Please ask for: Ms Iqraa Malik
Email: iqraa.malik@terraquest.co.uk
Telephone: 01212341390
Our Ref: AL/50/20/HH
Your Ref:
Date: 8th July 2020

Application for Planning Permission for Works or Extension to a Dwelling

Development: Replacement of existing conservatory with new garden room
Location: Limmer Pond Cottage Nyton Road Aldingbourne PO20 3TX

Dwg no:	05 Proposed Elevations
Date:	07.07.20
Drawn:	KAH
Revision:	-

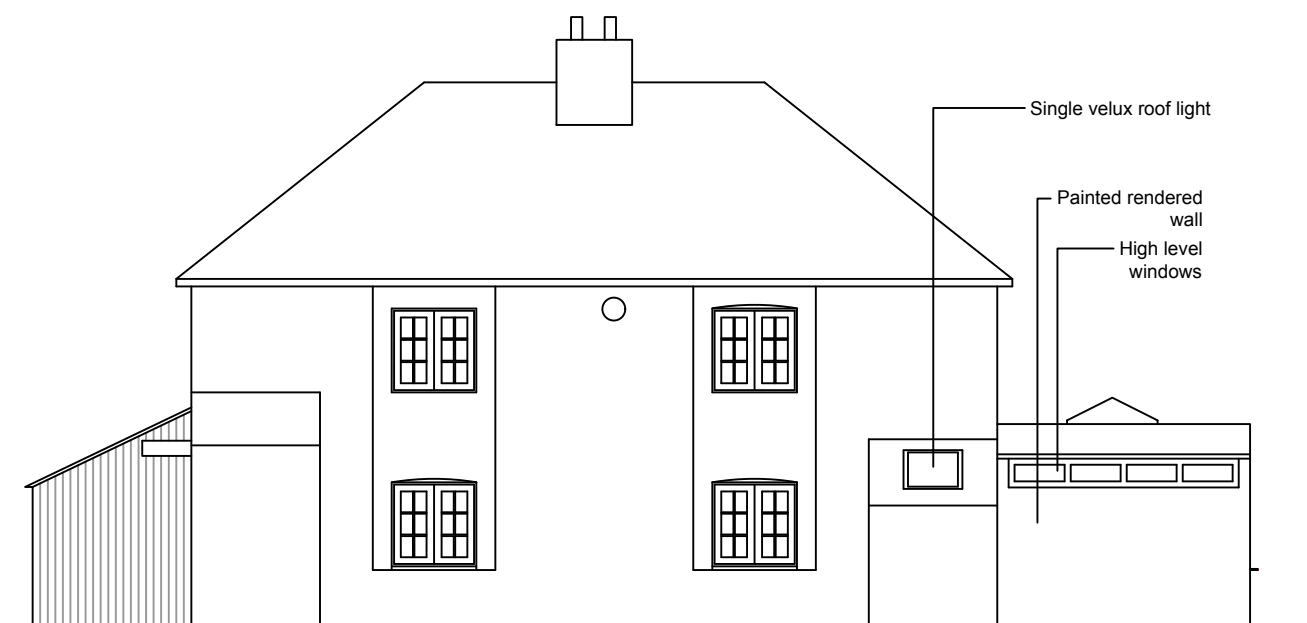
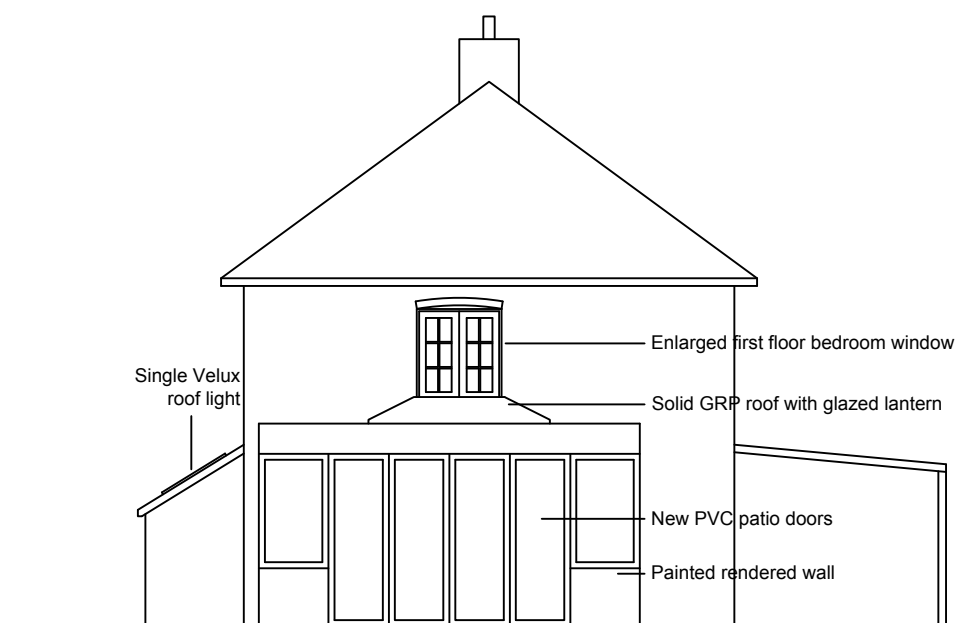
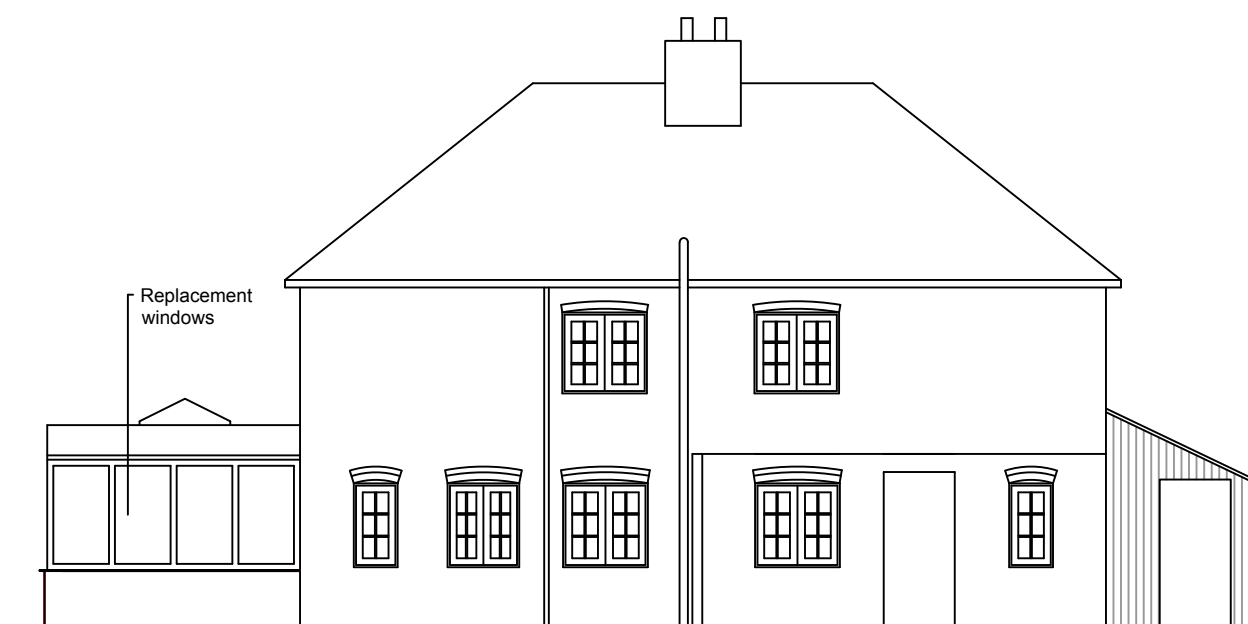
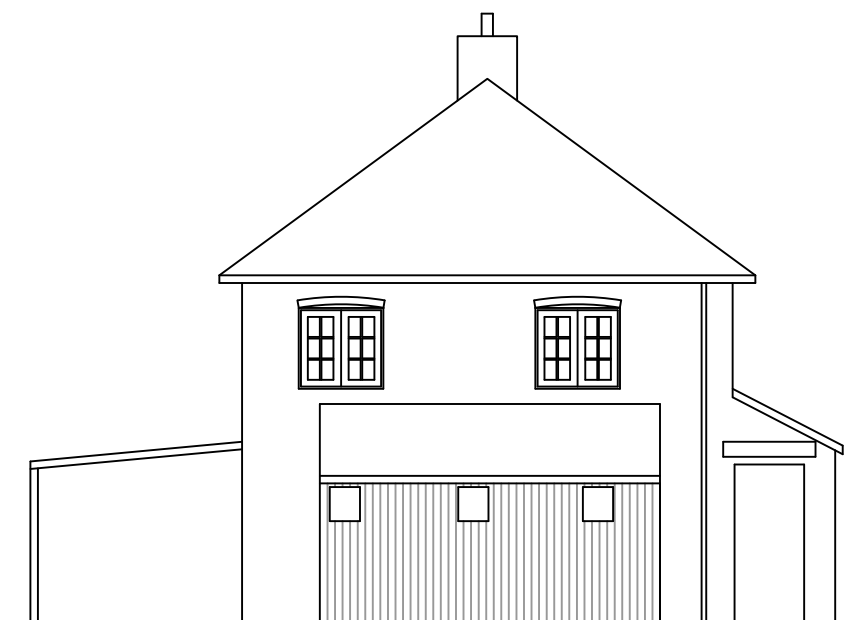
Elevations

You are required to have clear labels on your existing and proposed elevations. Please amend.

Dwg no:	01 Location and Block Plan
Date:	07.07.20
Drawn:	KAH
Revision:	-

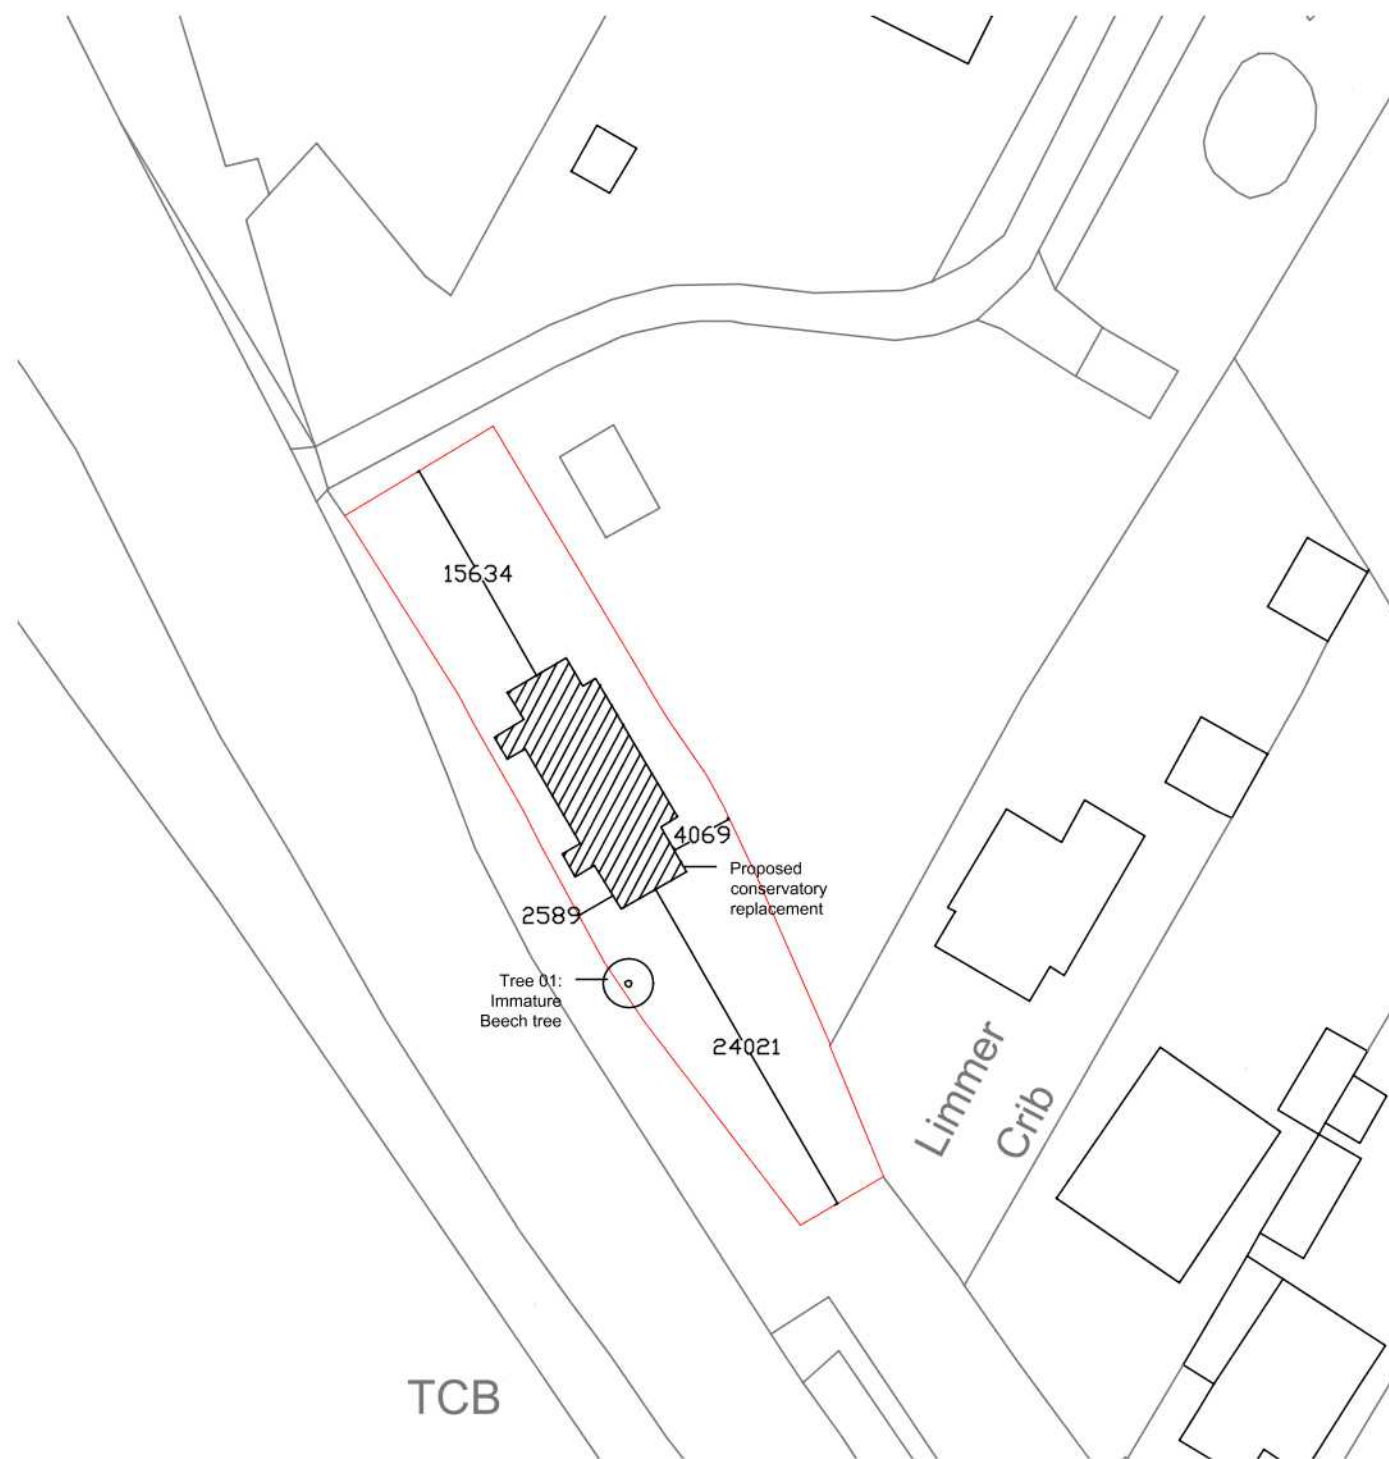
Location & Block Plan

You are required to have a scale bar on all plans. Please add this to your location and block plan. Please amend.

Block Plan

You are required to have dimensions from the proposed extension(s) to all site boundaries. Please amend.

Please confirm your address as you have outlined both 1 and 2 Limmer Cottage on your location plan.

Dwg no:	02 Floorplans
Date:	07.07.20
Drawn:	KAH
Revision:	-

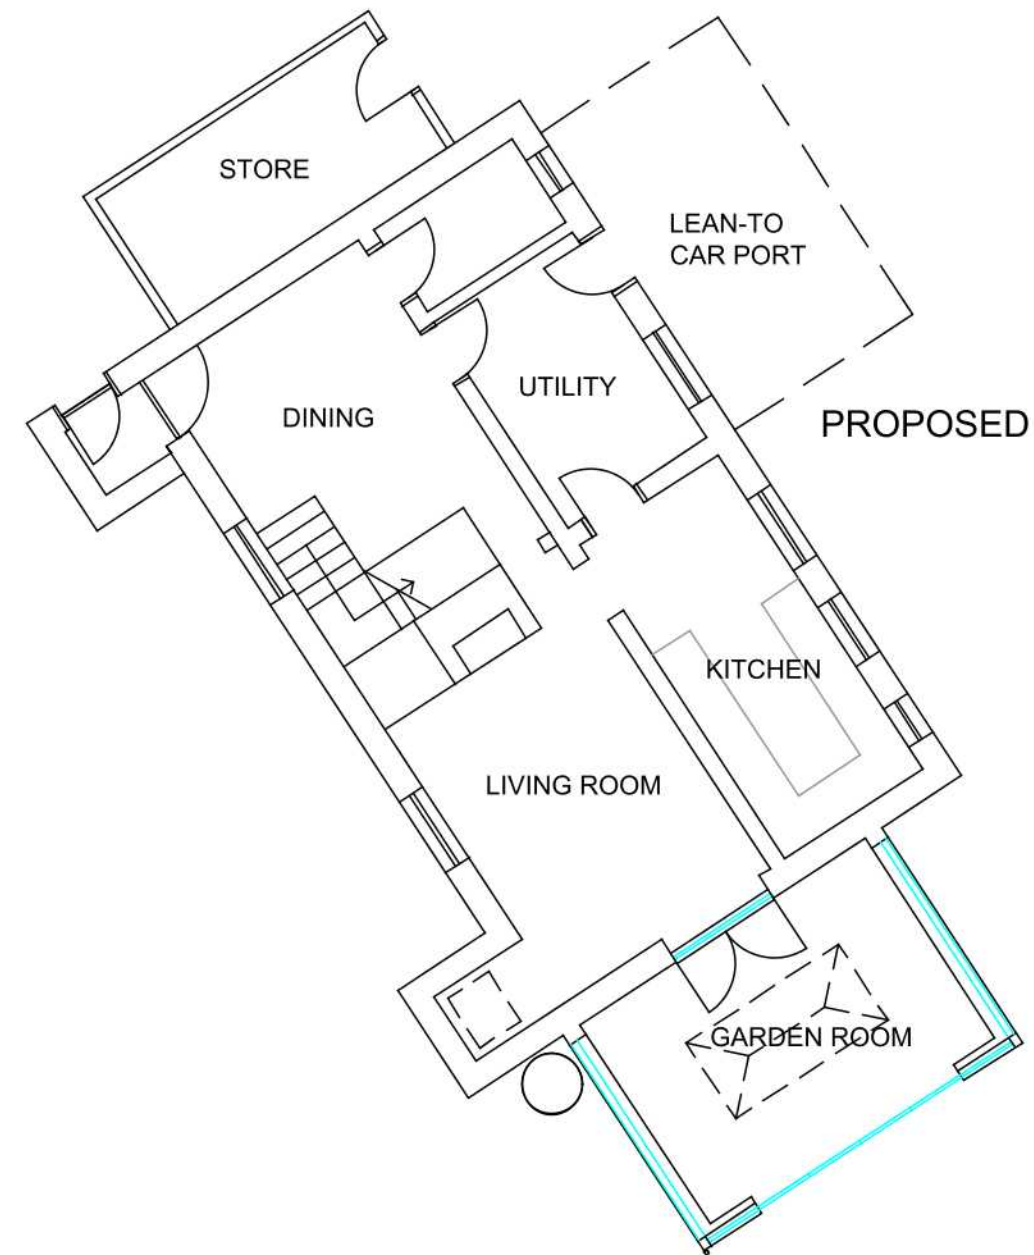
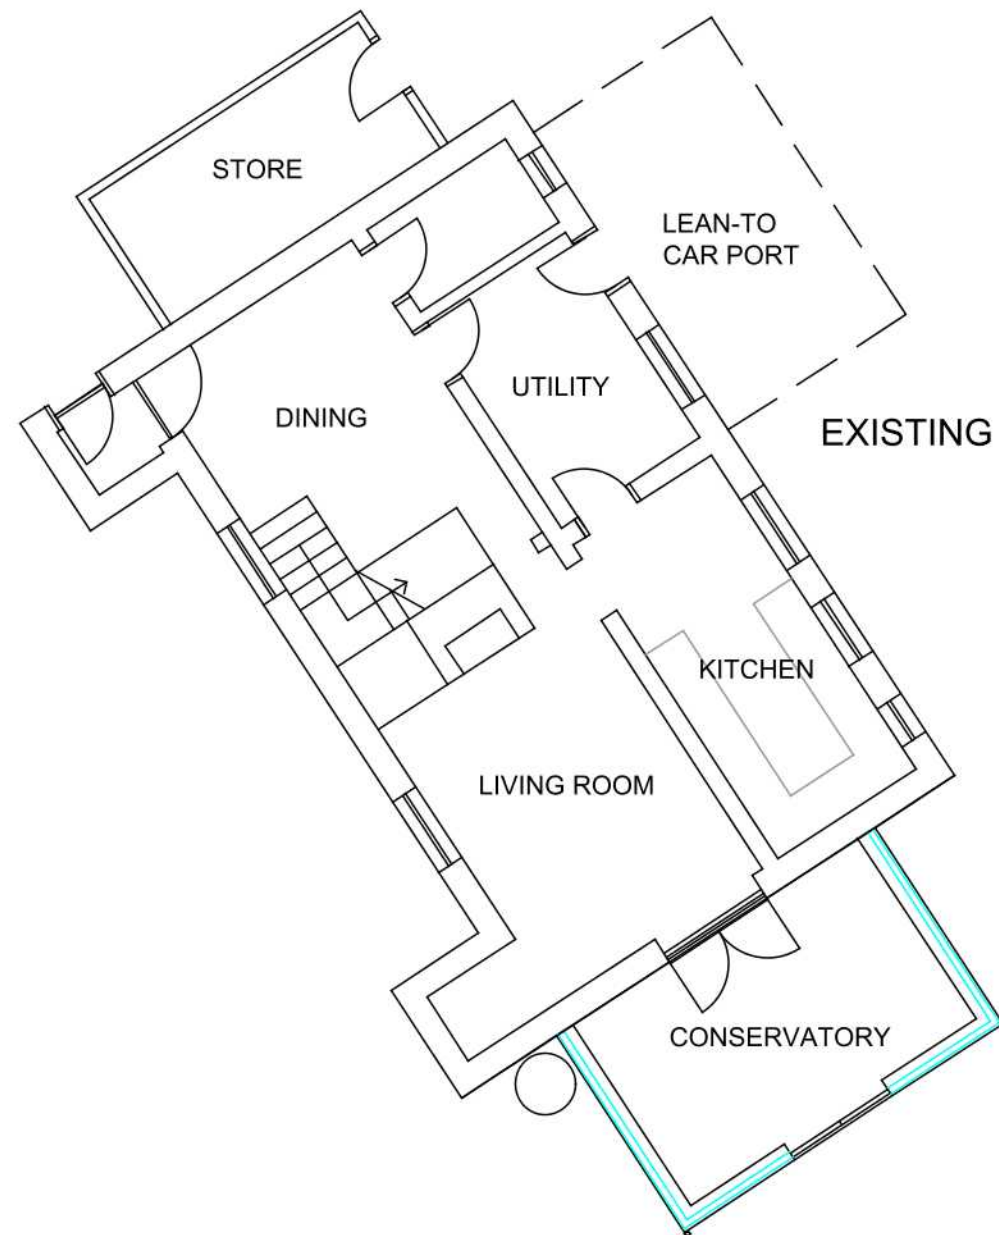
Floor Plans

You are required to have clear room labels on all floor plans. Please amend.

Dwg no:	06 First Floor plans
Date:	07.07.20
Drawn:	KAH
Revision:	-

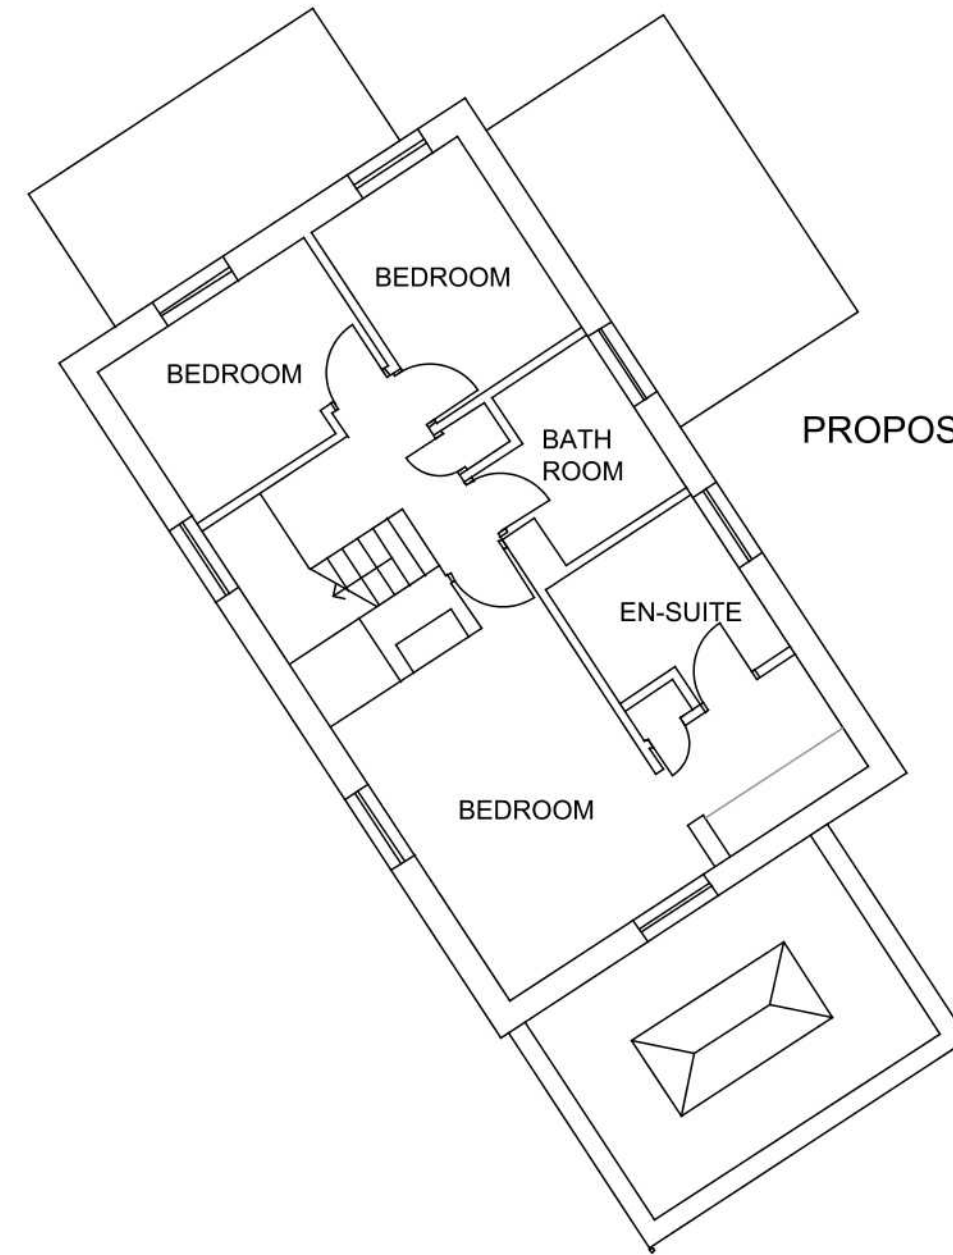
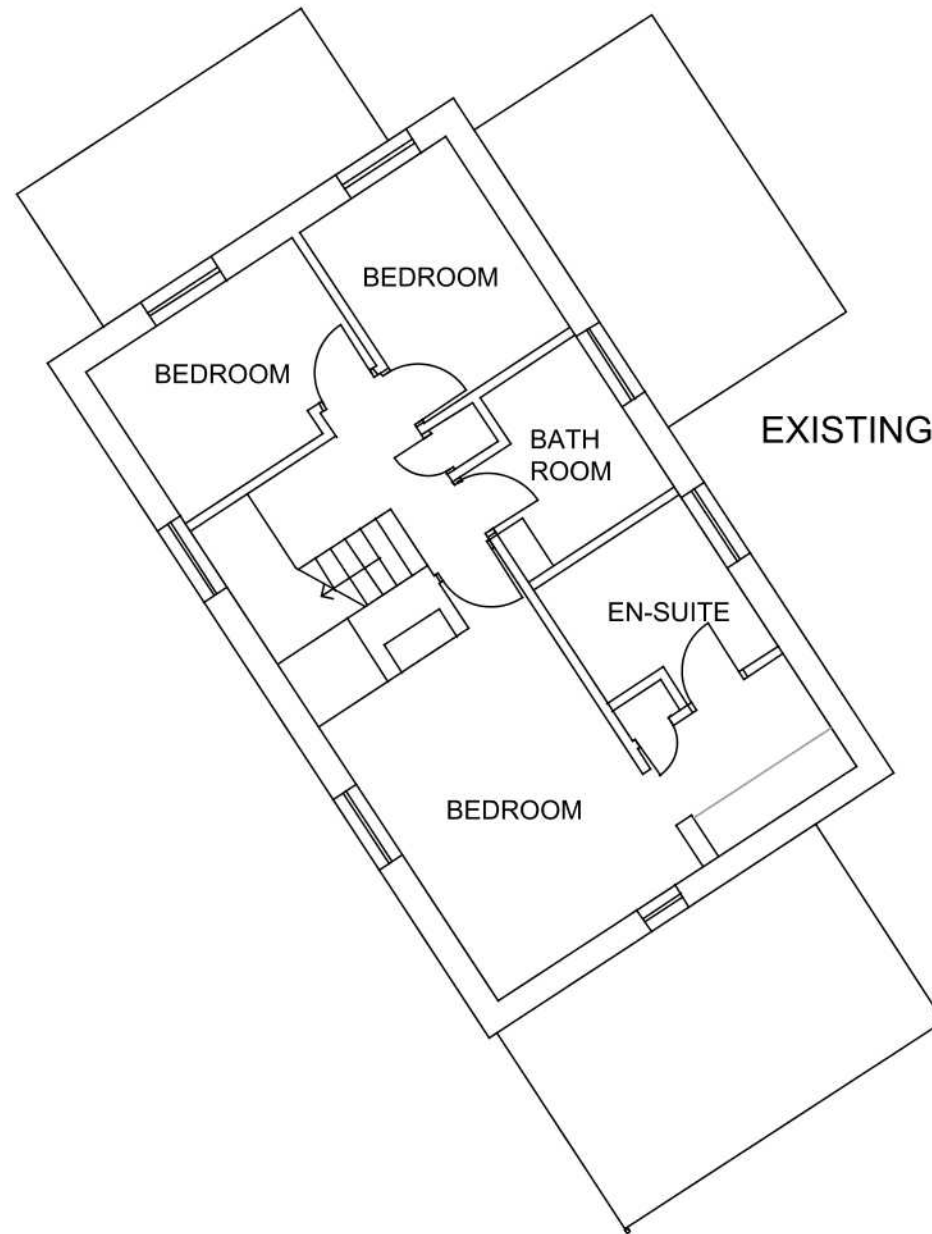
Floor Plans

Please submit clearly labelled existing and proposed first floor plans at a scale of 1:50 or 1:100.
